TEMPORARY CONSTRUCTION ACCESS, FORD LANE, YAPTON, WEST SUSSEX

DESIGNER'S RESPONSE TO ROAD SAFETY AUDIT STAGE 1/2

Project: 18-344

Report No.: 18-344-18

LARGE TIPPER: LEFT TURN IN

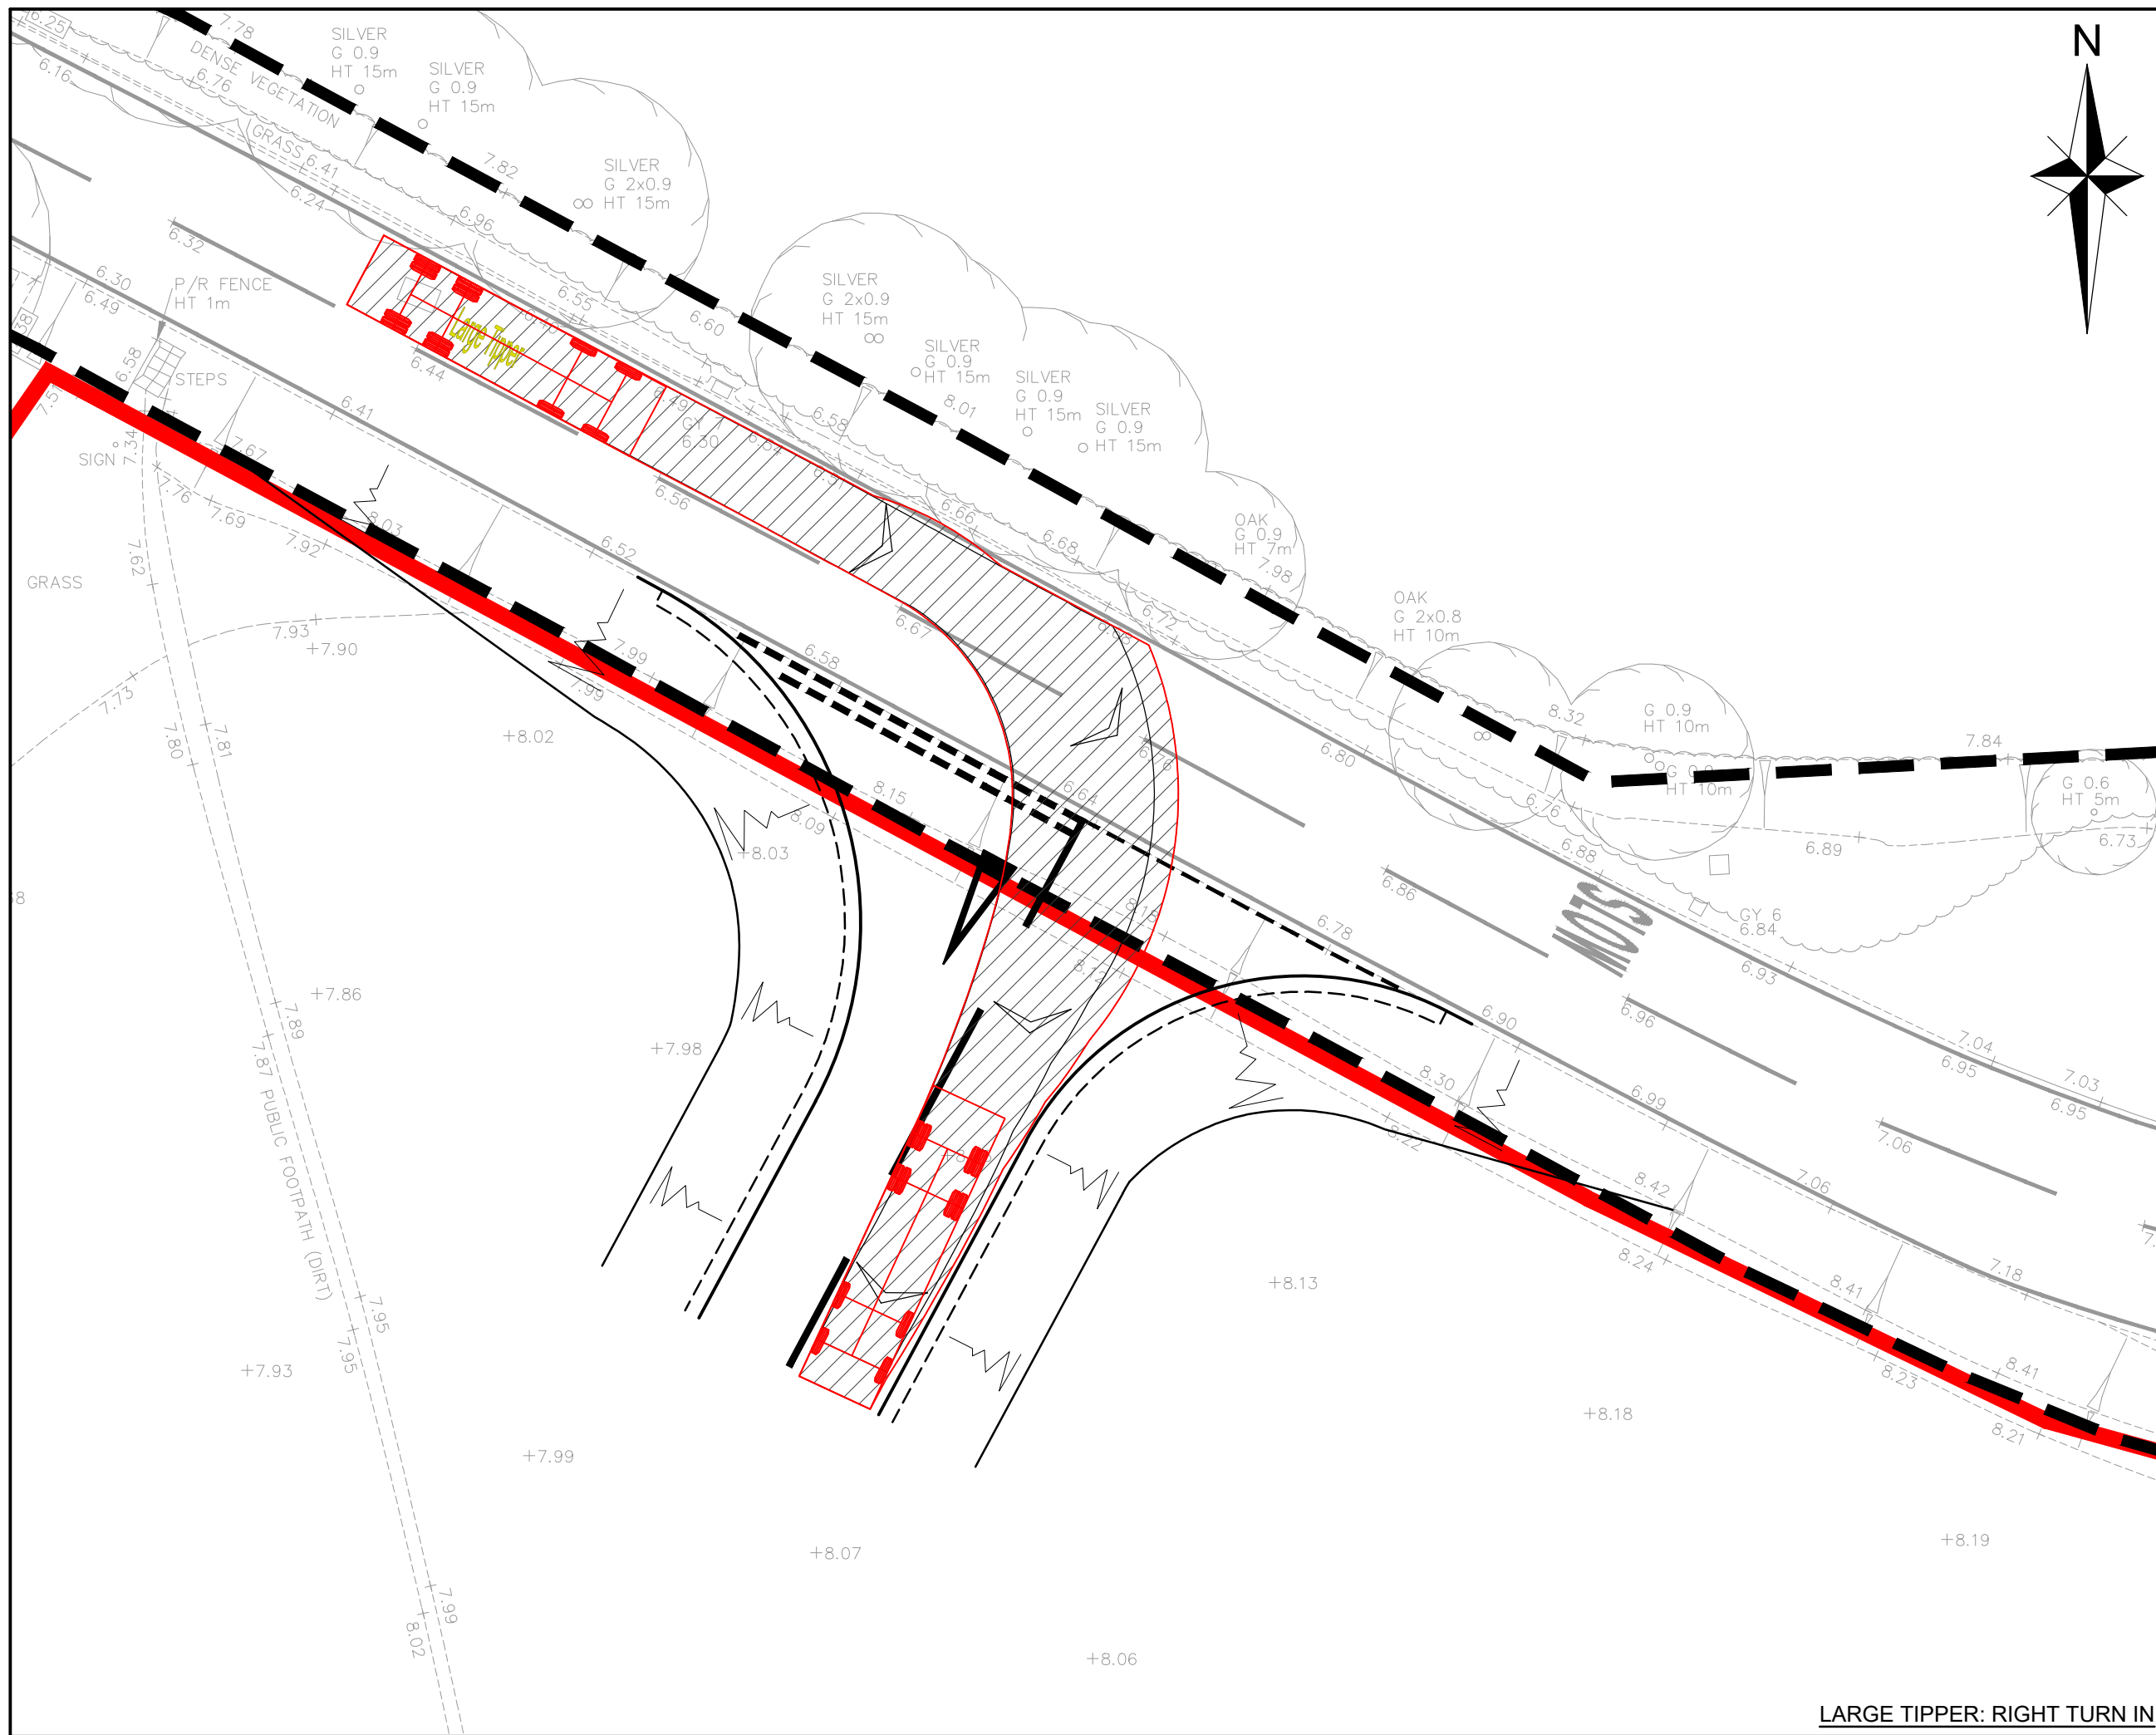
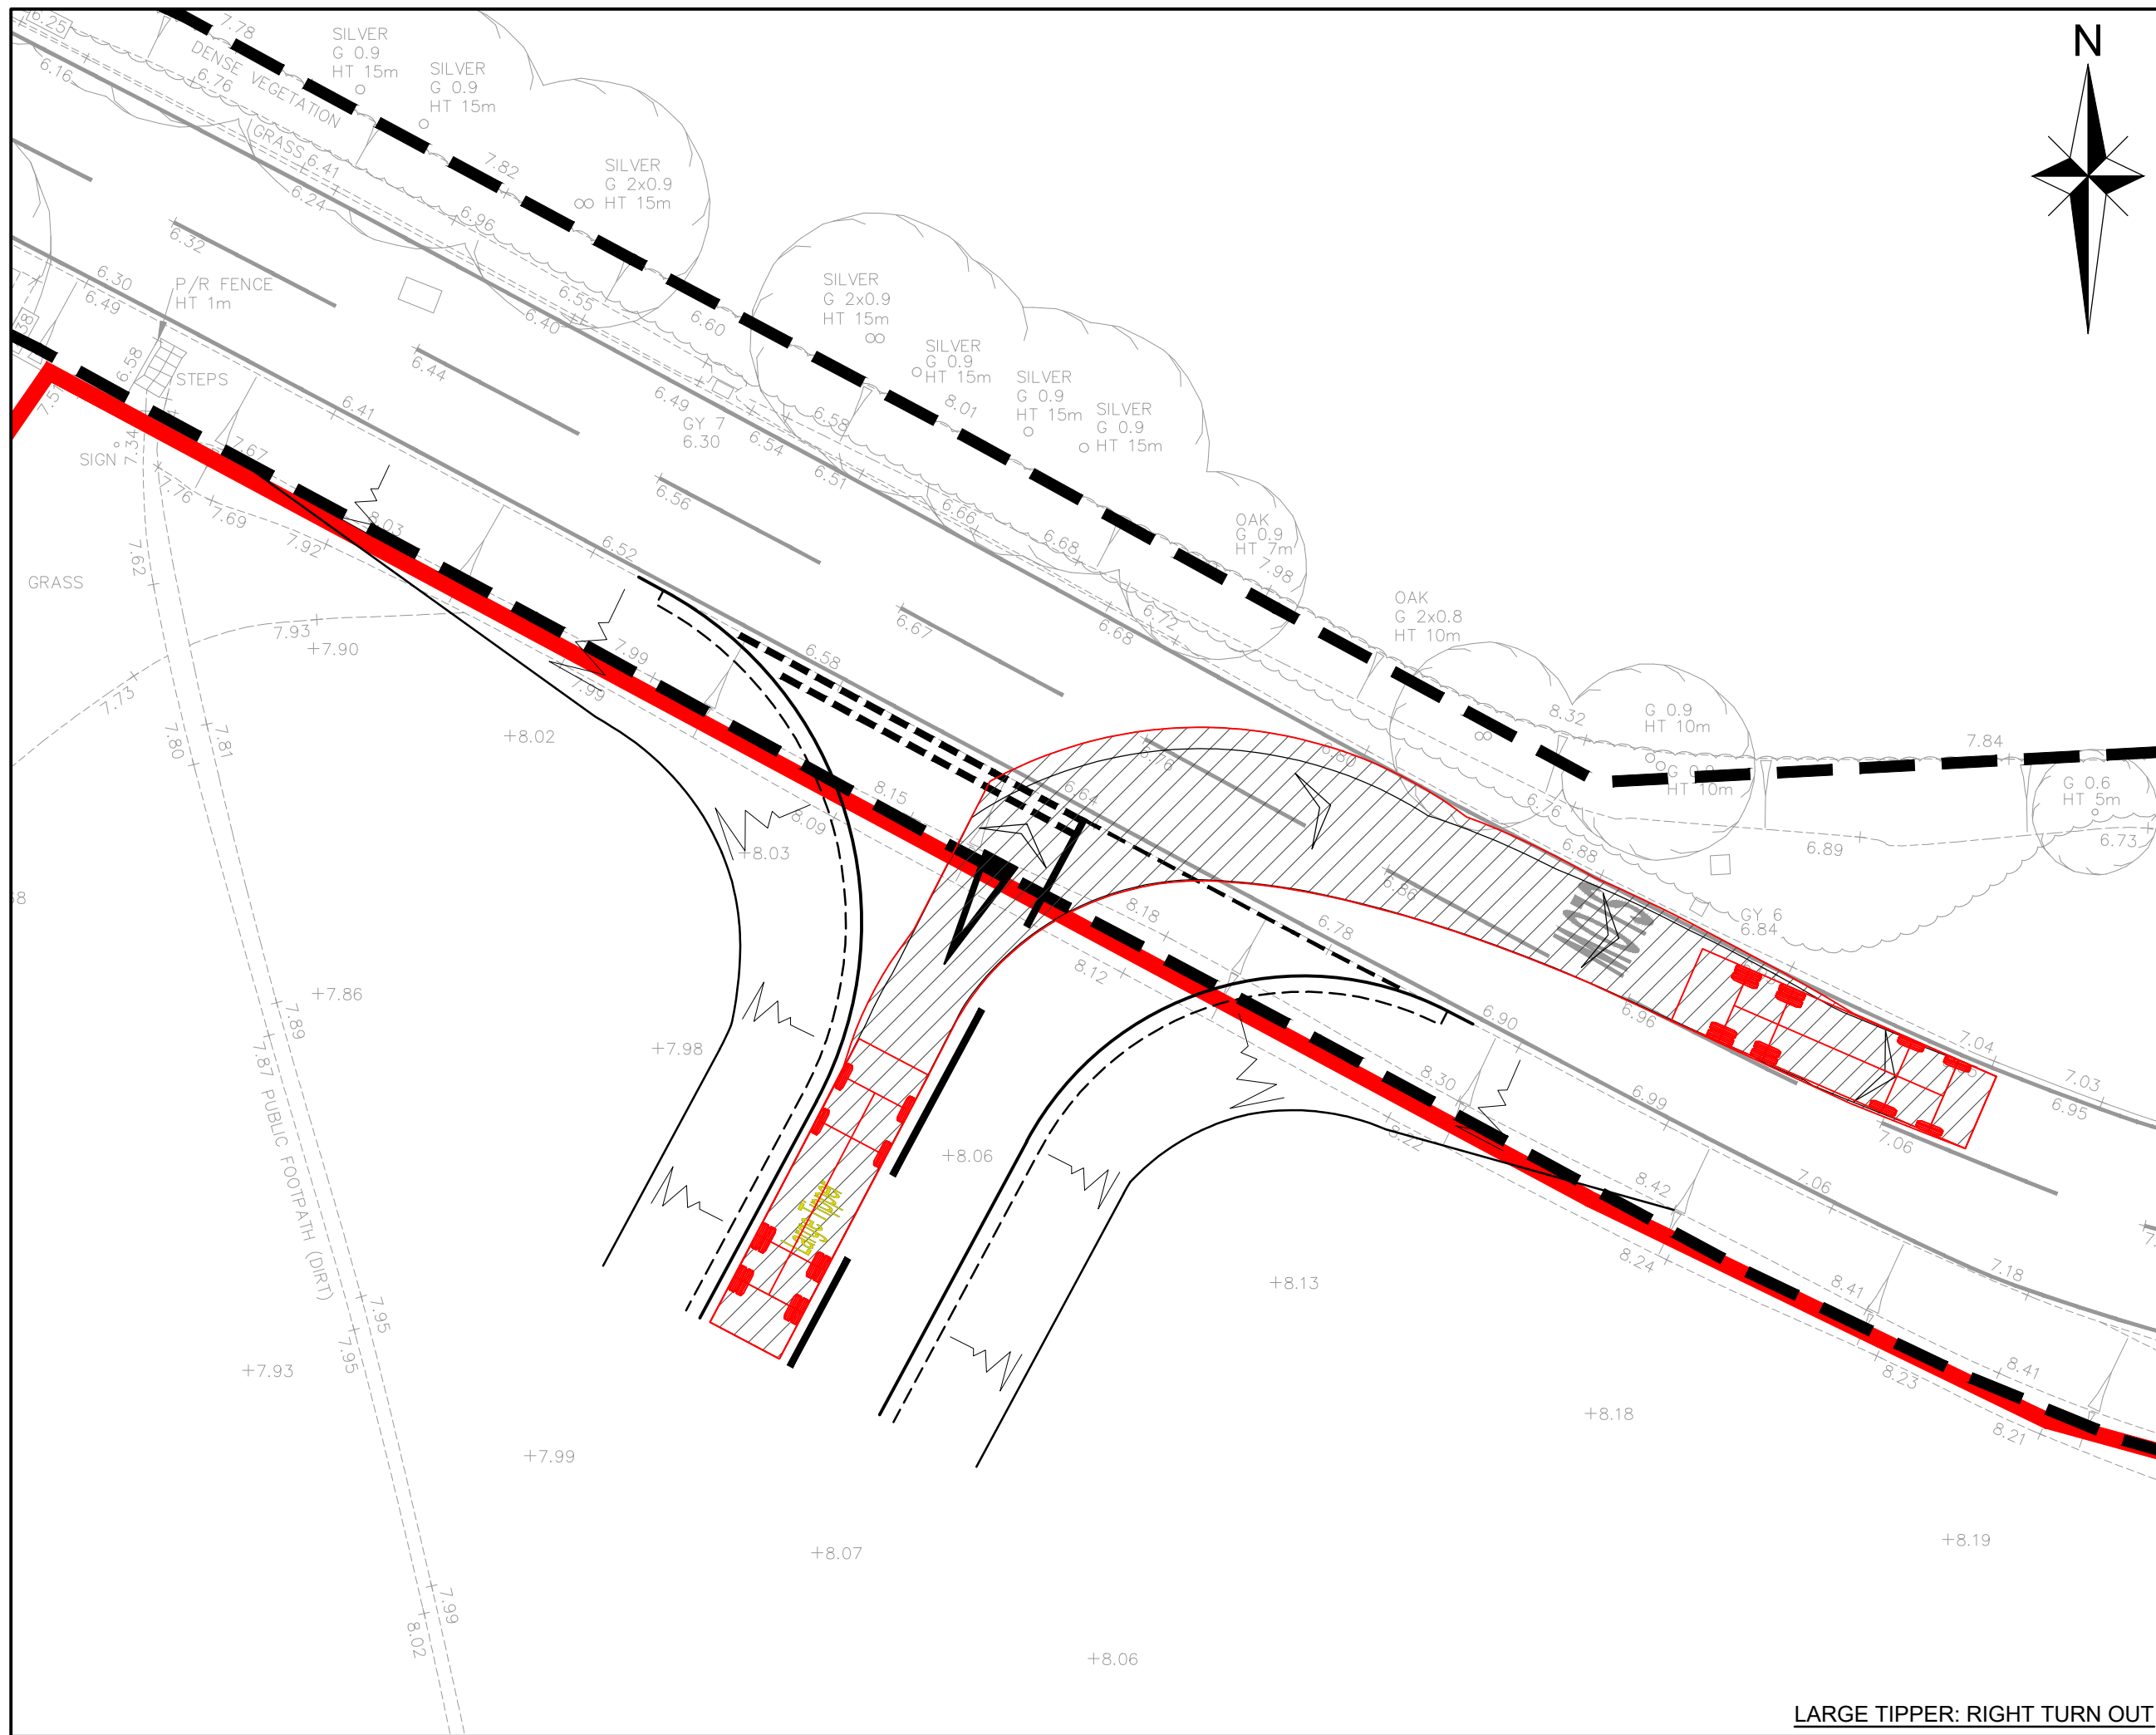
Audit Item No.	Audit Team Observation	Audit Team Recommendation	Odyssey Designer's Response	Client Comment
	Summary: Insufficient carriageway space could lead to rear end shunt head on or side impact collisions. The proposed temporary access is shown as being 5.5m in width and has a 6m radius on the south eastern side of the junction. Swept paths provided show marked deviations in paths taken to make the turns into and out of the temporary access., which could lead to head on collisions. There is concern that at 5.5m in width with the current radii that two-way HGV operation of the access will not be possible. This could lead to vehicles stopping or reversing onto Ford Lane, which could lead to rear end shunt head on or side impact collisions.	It is recommended that the temporary access and associated radii should be capable of accommodating simultaneous two-way HGV movements.	The junction layout is typical for this type of access/use. Provision of a layout to simultaneously accommodate two HVGs would make the access unnecessarily oversized and could lead to increased vehicle entry/exit speeds.
